CITY OF ALBUQUERQUE

May 2, 2022

Re: Chase Bank - ATM
5201 Ouray Road NW
Traffic Circulation Layout
Architect's Stamp 04-20-2022 (H11-D059E)

ENLARGED PROPOSED SITE PLAN

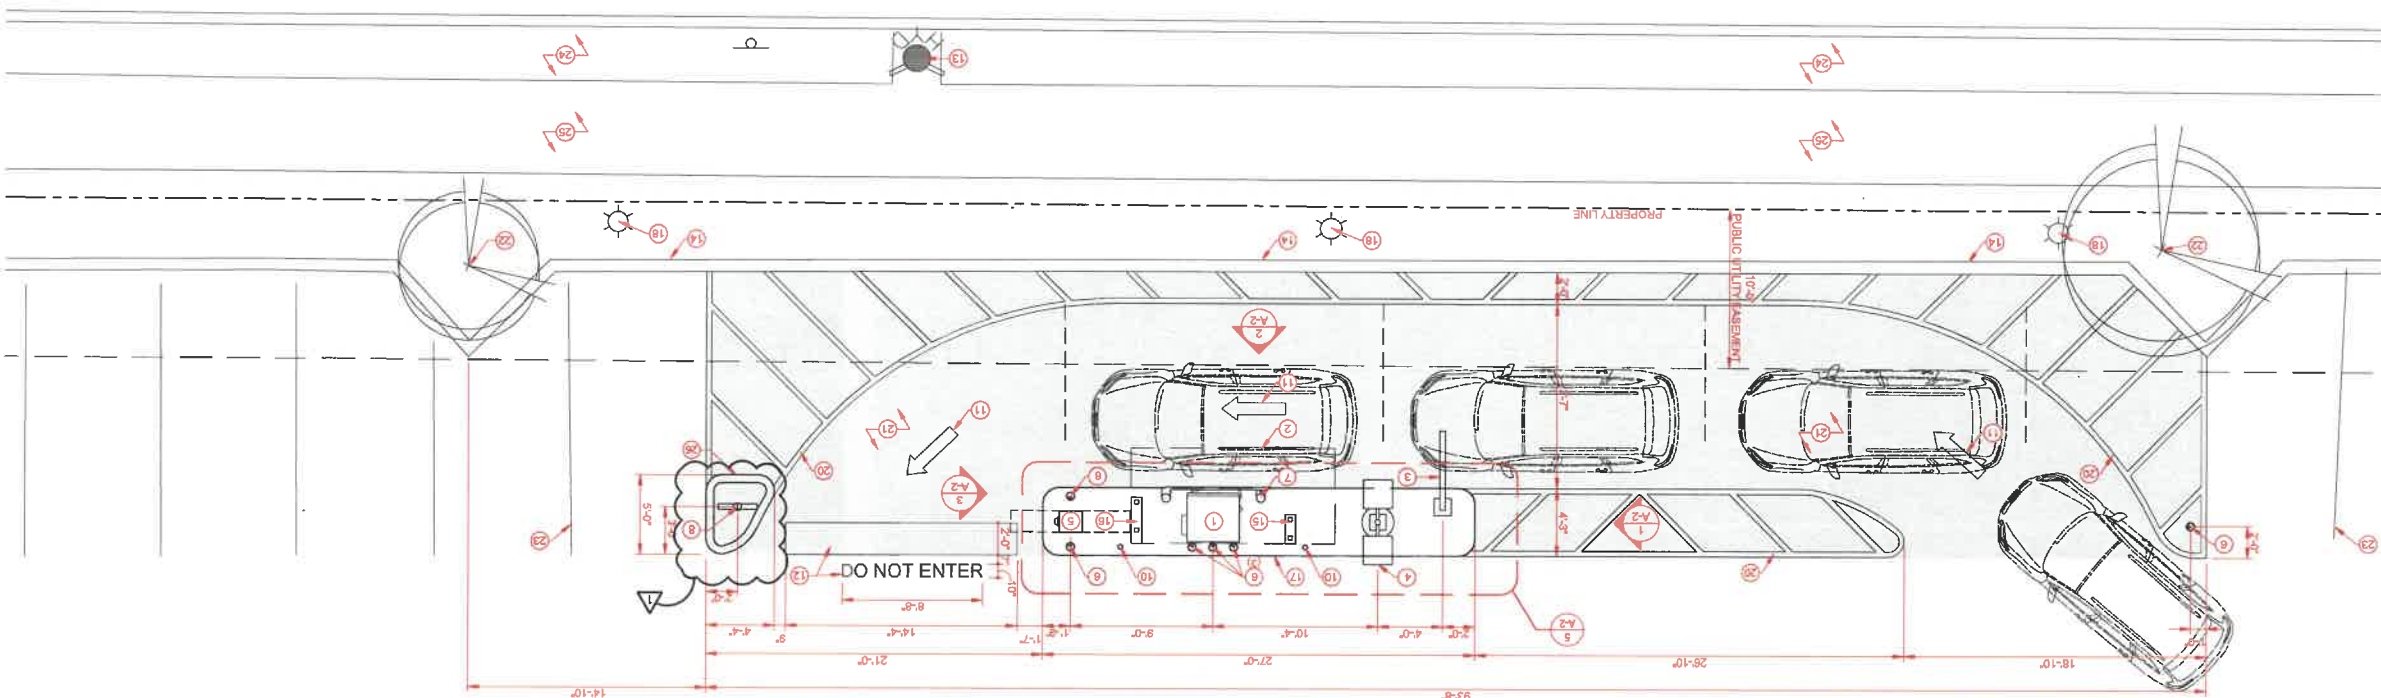
1. **Key Note 6:** Provide text to paint bollards traffic yellow.
2. **Key Note 8 – back to back signage:**
 - Provide shielding/curbing for proposed signage infrastructure to avoid being hit by vehicles.
 - Sign face should be perpendicular to traffic flow and not at any angle as shown.
3. **Key Note 12 - Details will be needed for the following items:**
 - Proposed stop bar (size and color).
 - 'DO NOT ENTER' – provide text size and color.
4. Please provide a letter of response for all comments given.
